Arun District Council,
BN17 5LF
Planning and Building Control.

'Melton'
Bundell Road,
Yapton
BN18 0HR
30th April, 2014.

LAND SOUTH OF FELLOWS GARDENS, YAPTON YN/18, 74/23/RES

CMP DETAILS

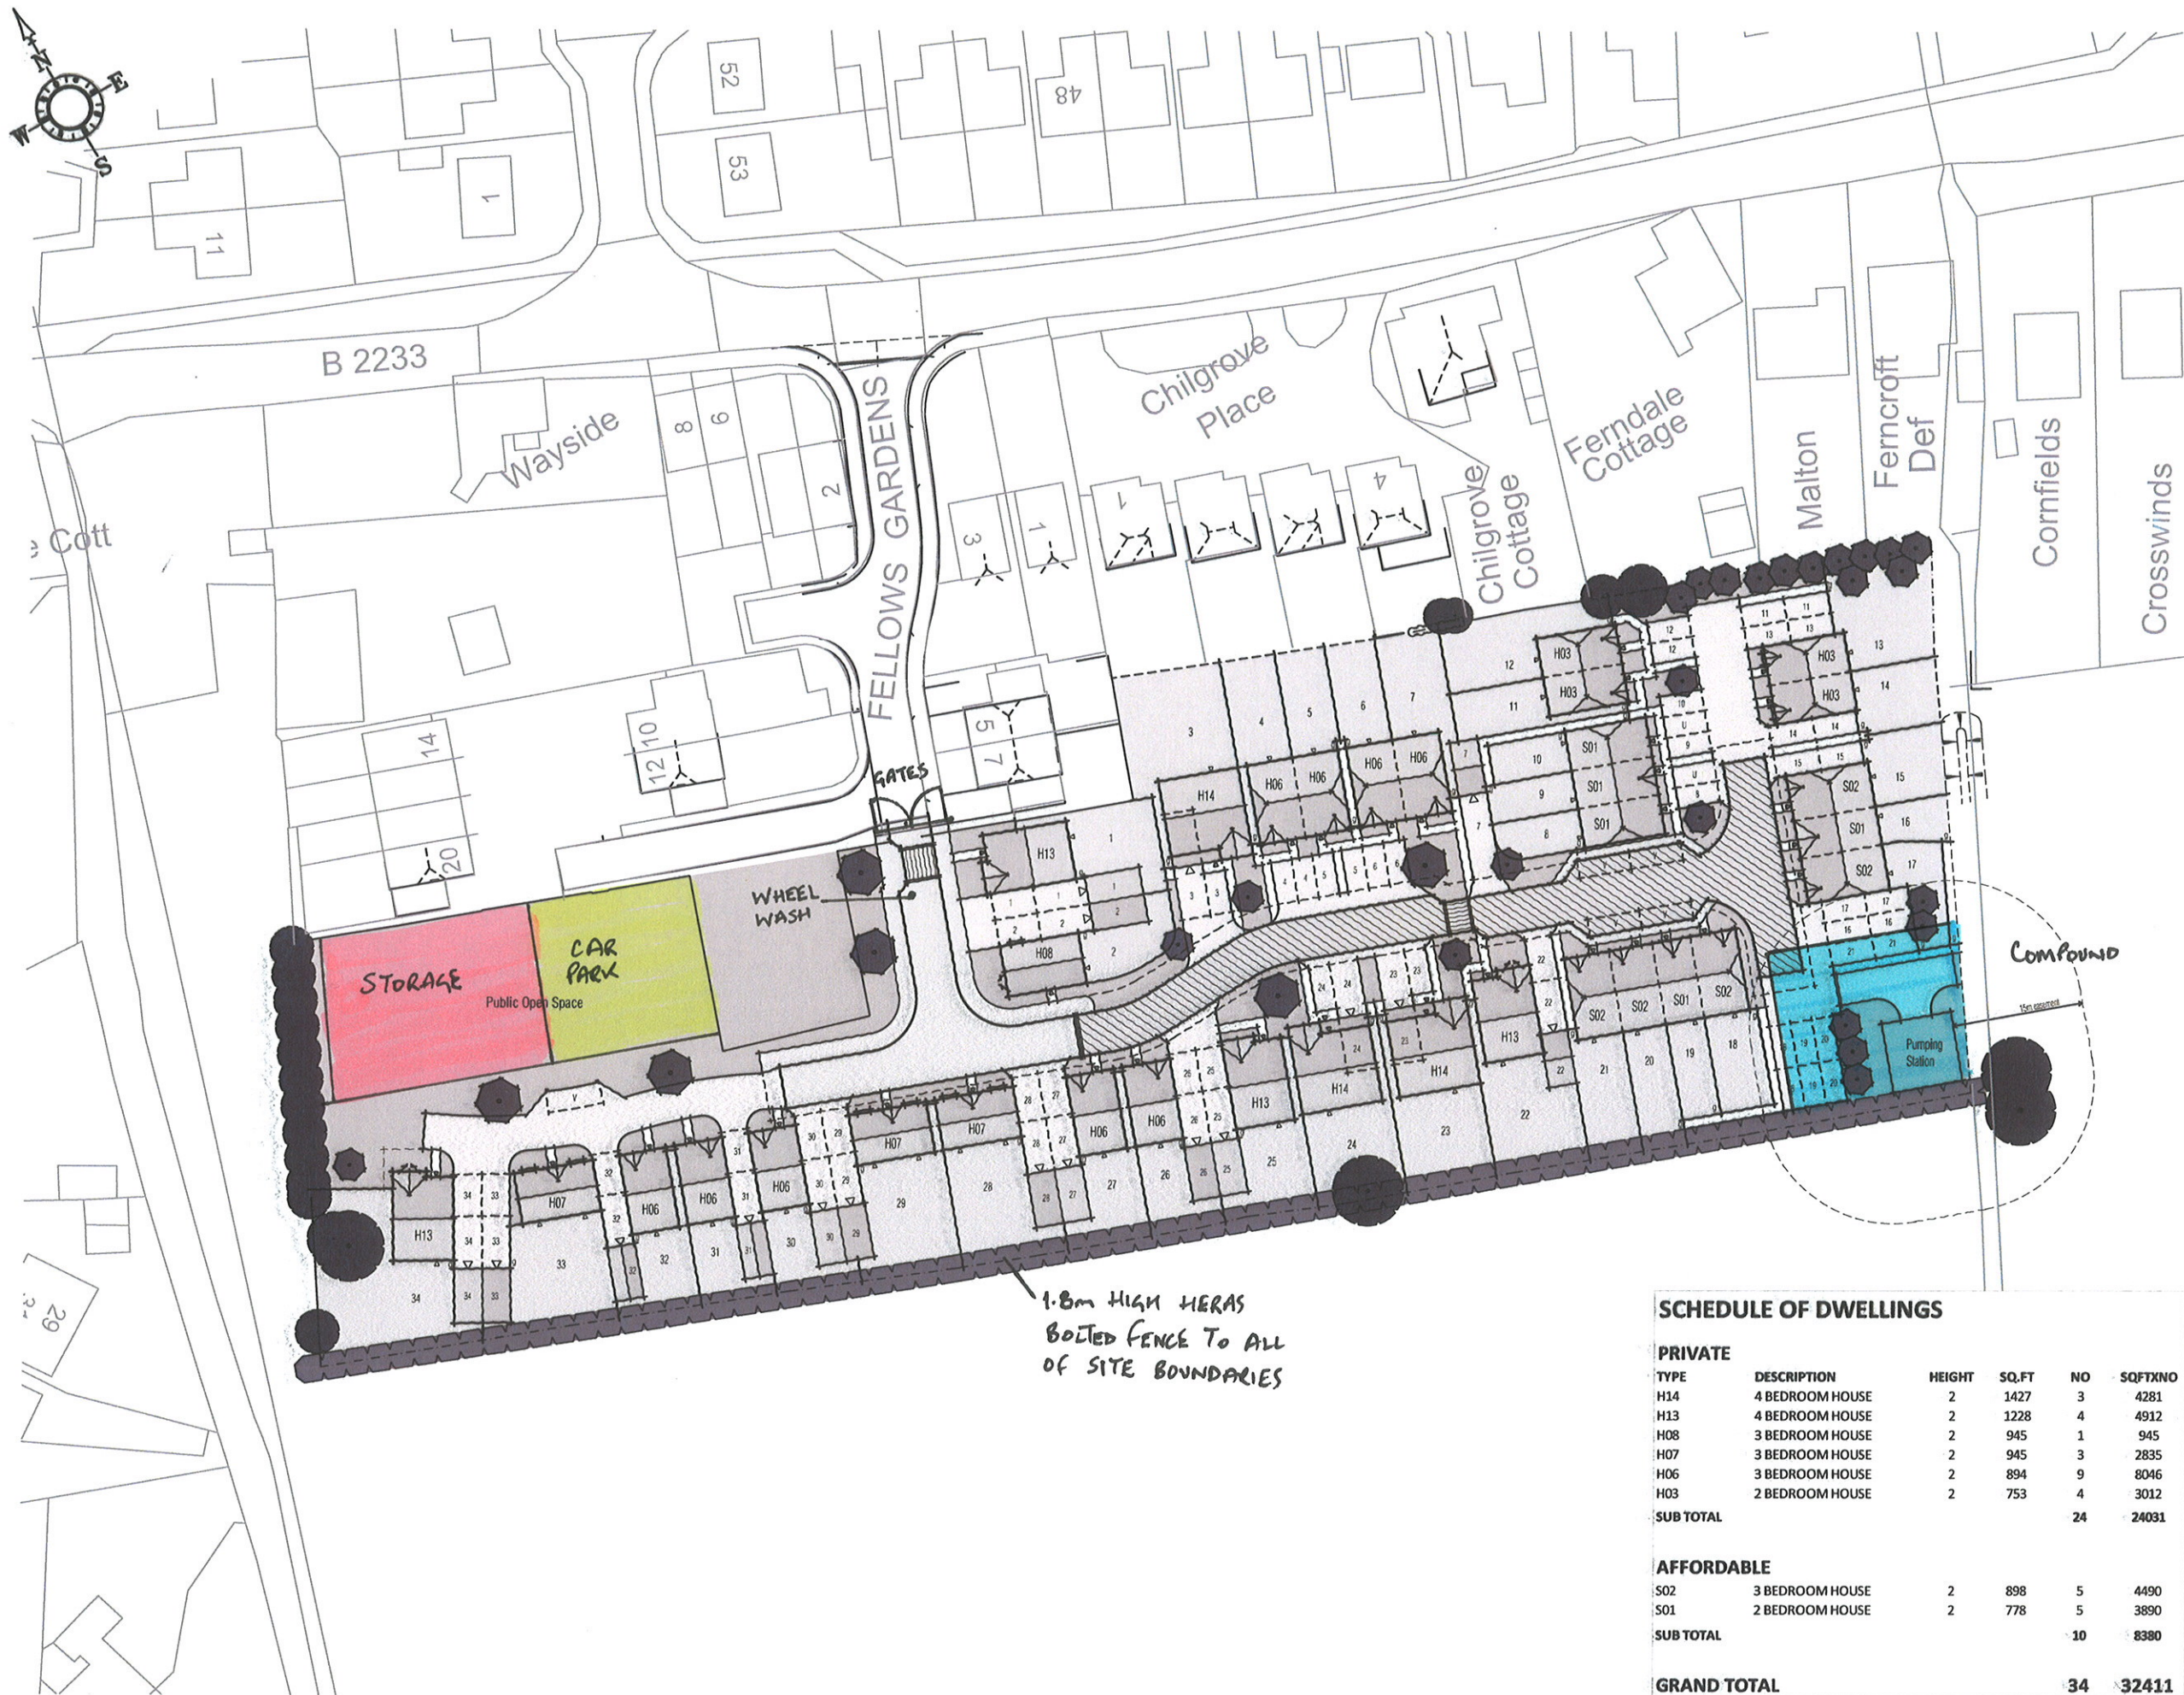
We also note that the fence is proposed to be 1.8m (5'10") high. We consider that to be totally inadequate to protect our privacy. Please insist on a 6' fence set on upstanding gravel boards.

We are also particularly interested in establishing precisely where the boundary fence will be situated. Looking at the scale plans, this might be to the immediate south of the present blackthorn stand of trees along our boundary. We would wish to have this confirmed.

STREET SCENES

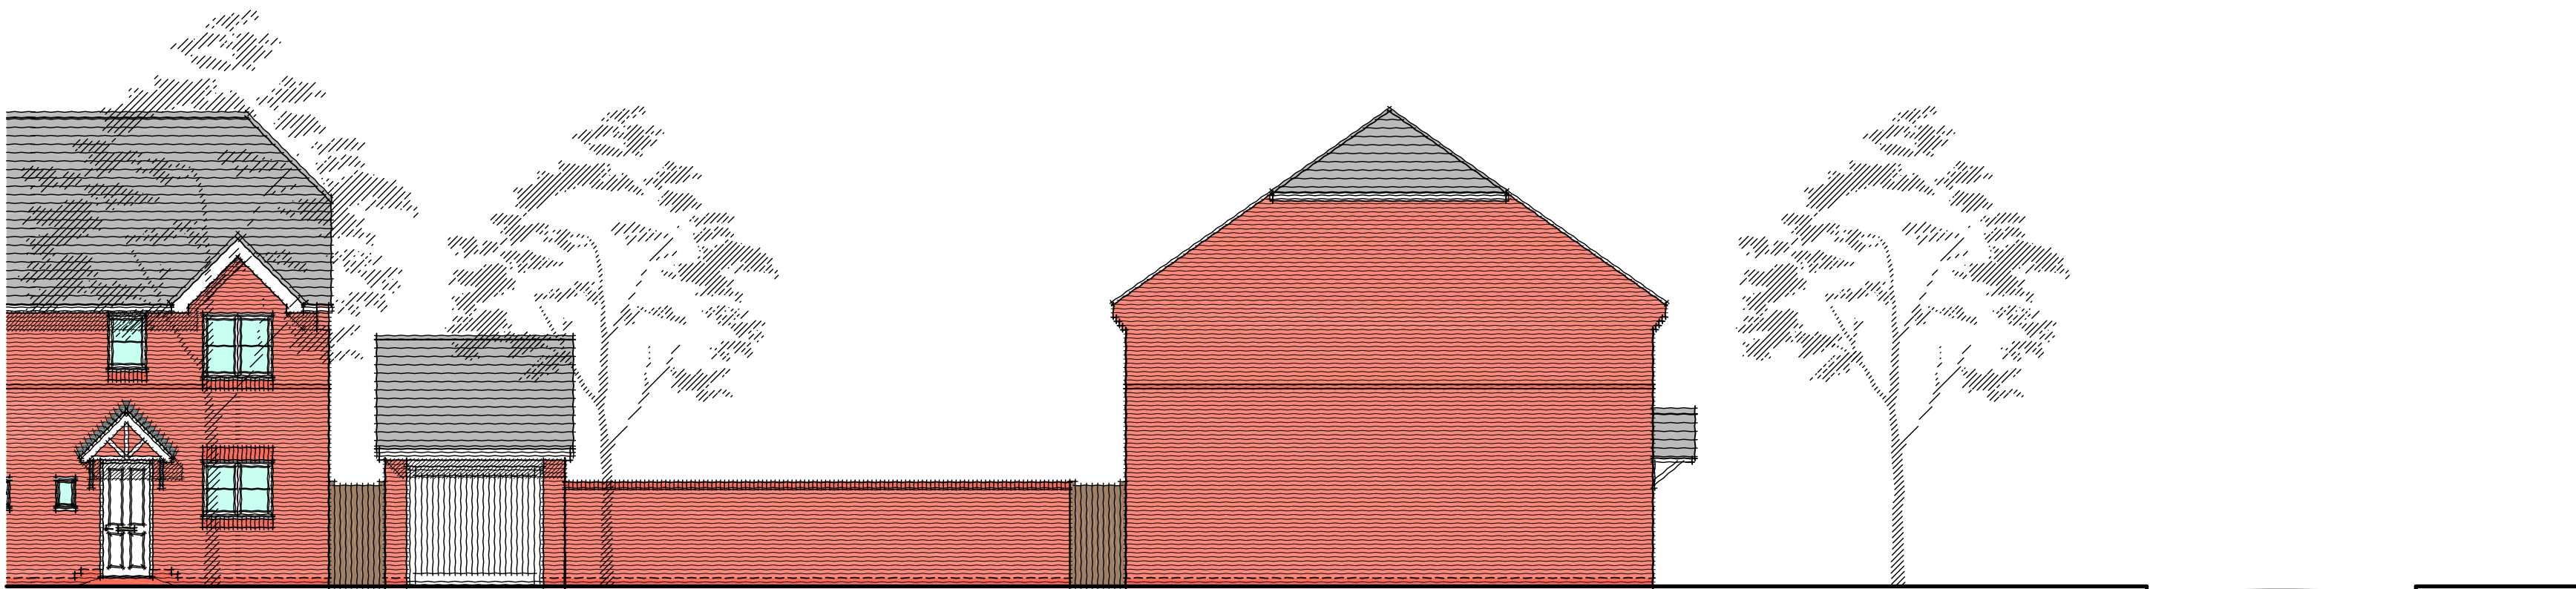
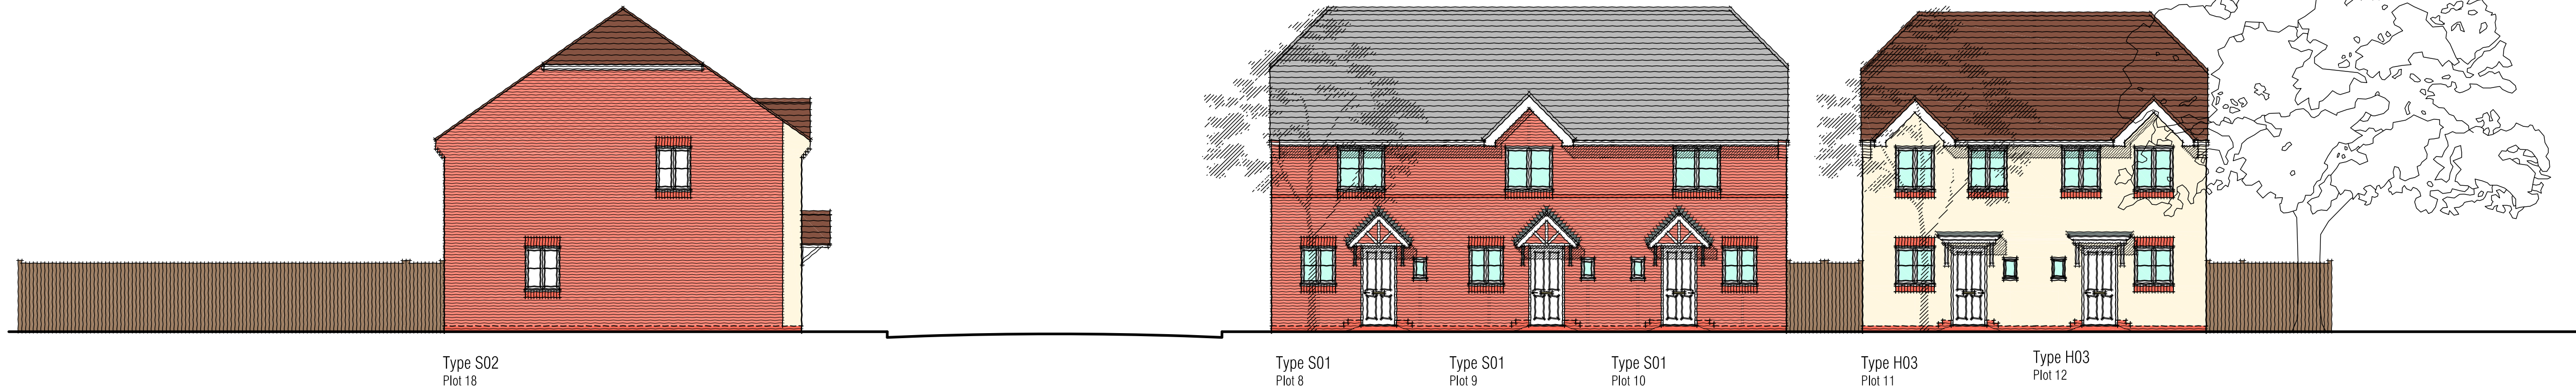
We are pleased that Ballway took note of and realised our request to further the houses from our, and our neighbours, boundaries by the width of a hedge and two car parking spaces. Although that is a great improvement, it still leaves us facing a blank, totally featureless red-brick side-facades of the houses. We originally discussed the possibility of the houses having fully hipped roofs. Presently we are offered semi-hipped roofs (presumably in line with other properties further along Bundell Road). We would rather our side (the northern side) of these houses to be fully hipped. If not, at least clad along their upper face down to gutter level, or even lower.
